Our Ref: P/152/25/DOC

Approval of details reserved by condition imposed under P/92/25/S73 relating to condition 4-details of kitchen equipment.

Kingfisher Manor Pine Marten Close Pagham PO21 3WE

Arun District Council have decided to **REFUSE details reserved by condition for the following reasons:**

SUMMARY FAN DATA SHEET

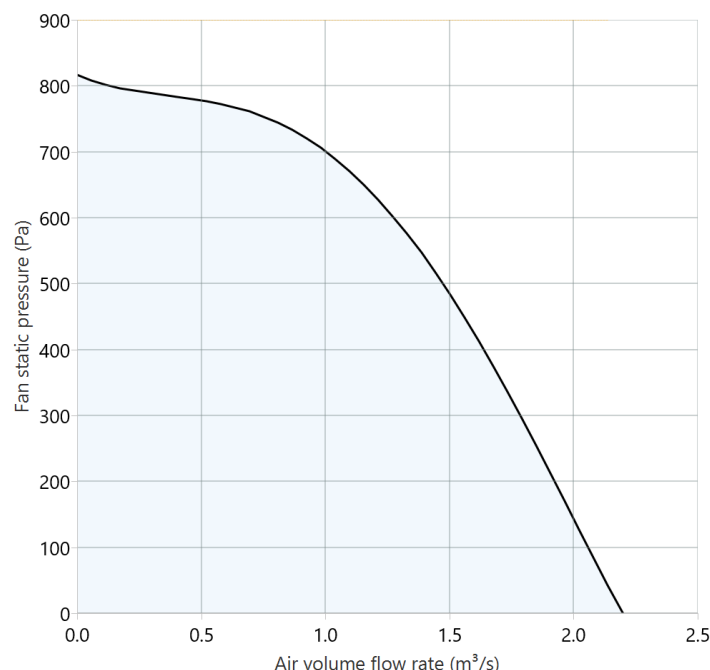
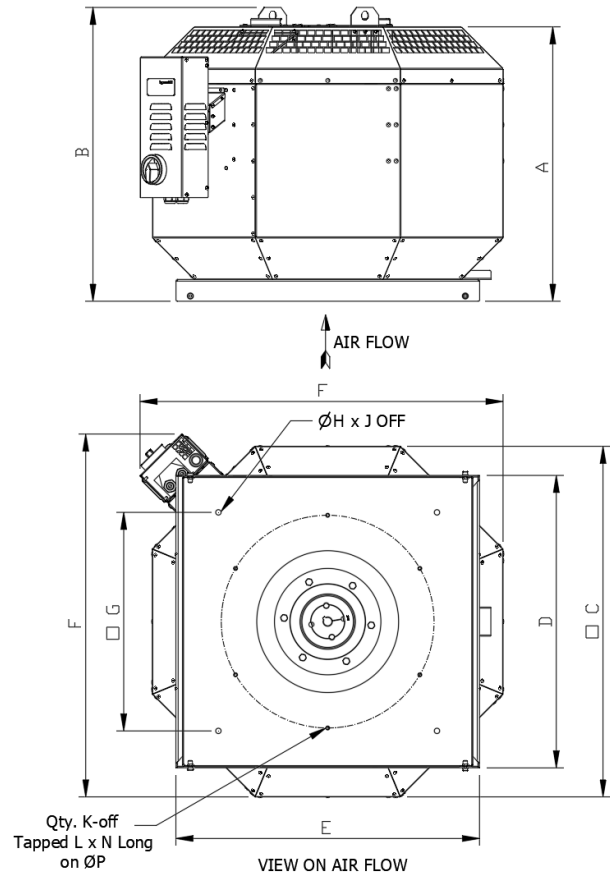
- Incorrect details regarding the fans;
- Insufficient noise data.
